## M25 junction 28 improvement scheme

### 9.114 Applicant's comments on Transport for London's Deadline 7 submission

<b>Rule Number:</b>	Rule 8(1)(k)
<b>Planning Inspectorate Scheme Reference</b>	TR010029
<b>Application Document Reference</b>	TR010029/APP/9.114
<b>Author:</b>	M25 junction 28 scheme, Project Team, Highways England

<b>Version</b>	<b>Date</b>	<b>Status of Version</b>
0	9 June 2021	Deadline 8

TRAFFIC MANAGEMENT LAYOUT 2
A12 EASTBOUND NARROW LANES

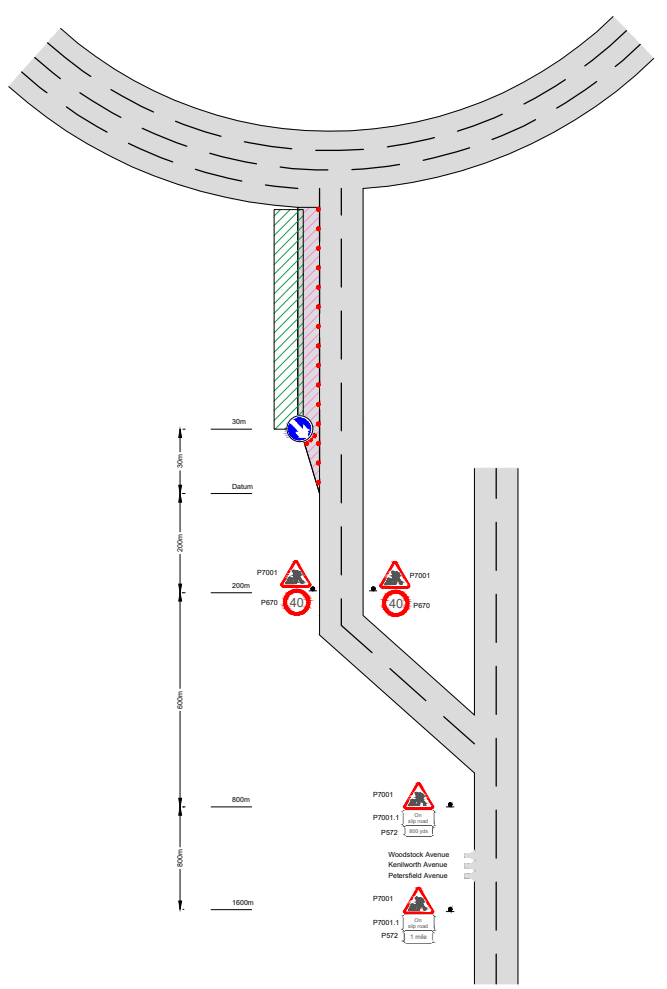
Response reference:	Question	Highways England Response
	<p>this point would be addressed, including arrangements for escorting emergency services through a closure on the A12 eastbound off slip road should this be necessary.</p>	
REP7-042-11	<p>2.2.4 Thirdly, TfL has raised concerns about the narrow lane running required on the A12 eastbound carriageway, and in particular the comment in the outline TMP that the narrow lanes required may increase potential hazards to pedestrians and therefore nearside lane closures of the A12 may be necessary instead (reference REP4-013 paragraph 2.3.14). This would have been of great concern to TfL because lane closures on the A12 carriageway during peak periods would have substantial adverse impacts on traffic flows and delay. The Applicant subsequently set out that the narrowing of lanes would be towards the central reservation and a protective barrier for pedestrians would be provided (reference REP6-011 question TA 2.4 paragraph 4.5) therefore no lane closures of the A12 carriageway would be required at peak times. TfL stated at the hearing that the outline TMP should be updated</p>	<p>Clarification that closure of the nearside lane on the A12 eastbound carriageway will only take place during off-peak periods, and not during the peak periods, is provided in the amended Outline TMP submitted at deadline 7 (REP7-017).</p>

Response reference:	Question	Highways England Response
	<p>accordingly to specify that lane closures on the A12 eastbound carriageway at peak times will not be necessary. The Applicant agreed to make this change.</p>	
REP7-042-12	<p>2.2.5 The final point TfL raised on the outline TMP was on a related matter, concerning the Applicant's comments on TfL's responses to the ExA's Further Written Questions which specified that the footway along the A12 eastbound off slip will need to be closed for an extended period during construction (reference REP6-011 question TA 2.4 paragraph 4.5). The Applicant explained at the hearing that pedestrians on the north side of the A12 would need to walk west towards London to use the subway under the A12 at the junction with Petersfield Avenue to access the footway on the south side of the A12 during this time. TfL made clear at the hearing that this footway closure would need to be carefully managed with appropriate signage and other measures in place to reduce the risk of pedestrians trying to cross the A12 carriageway at non-designated locations. TfL perceives this to be a risk because of the length of the diversion route for</p>	<p>Section 2.3.28 and Table 2-1 of the Outline TMP (REP7-017) sets out the proposed approach to temporary arrangements required for pedestrian diversions during construction works. The details of these will be set out in the Final TMP.</p>
